## Application by Rosefield Energyfarm Limited for the Rosefield Solar Farm

The Examining Authority's second written questions and requests for information (ExQ2): issued on 5 June 2026

FIGURE NUMBER:
Figure 2.3

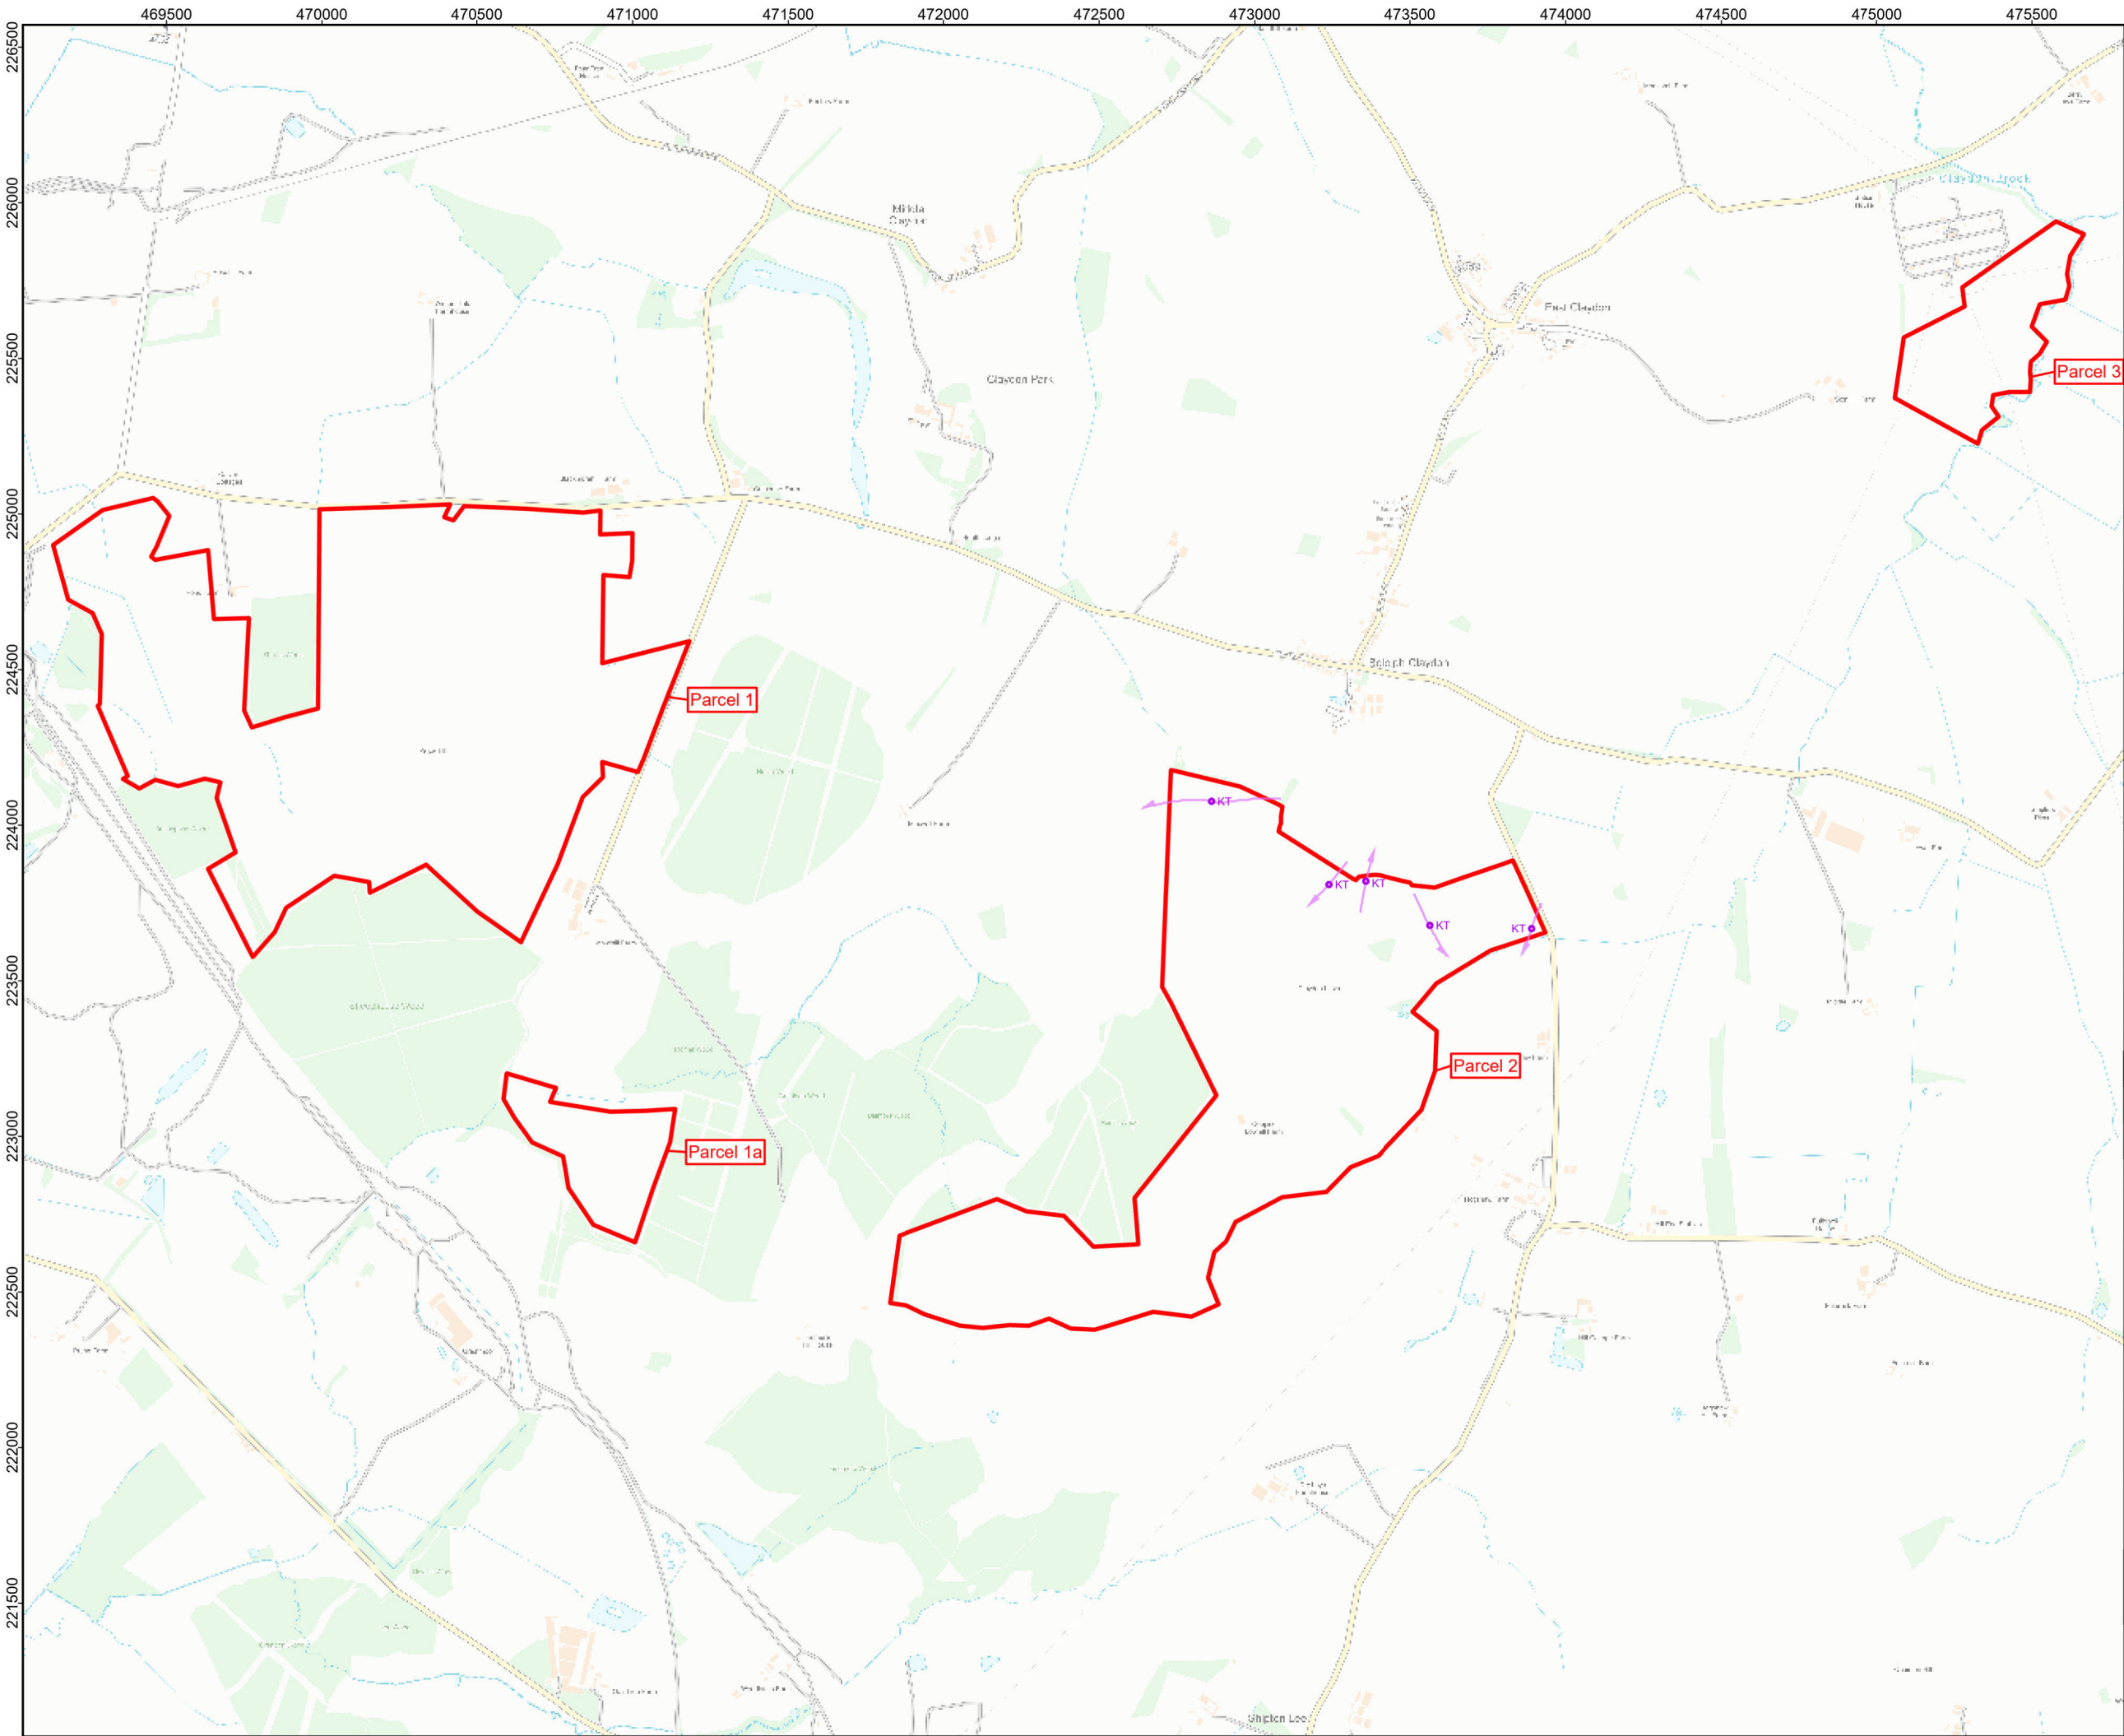
Q2.2.7	The applicant	<b>Site selection – alternatives</b> Provide further explanation for the drawing of the “site boundary” identified in the Wintering Bird Survey Report undertaken in 2022 <a href="#">[APP-089]</a> .
<b>3. Air quality</b>		
Q2.3.1	Preston Farms Limited and TCS Biosciences Limited	<b>Battery Energy Storage System (BESS) – Plume Assessment</b> Following discussions at issue specific hearing 1 (ISH1) on your critical review of the BESS Plume Assessment by a battery safety expert <a href="#">[REP2-107]</a> the applicant has updated its BESS Plume Assessment Summary <a href="#">[REP3-042]</a> and included commitment D25 in its Design Commitments <a href="#">[REP3-010]</a> “BESS containers and transformer units will be offset at least 50m from the southern boundaries of fields D8 and D9 and the eastern boundary of field D9  Has this addressed all your concerns? If not, what further action should the applicant take?
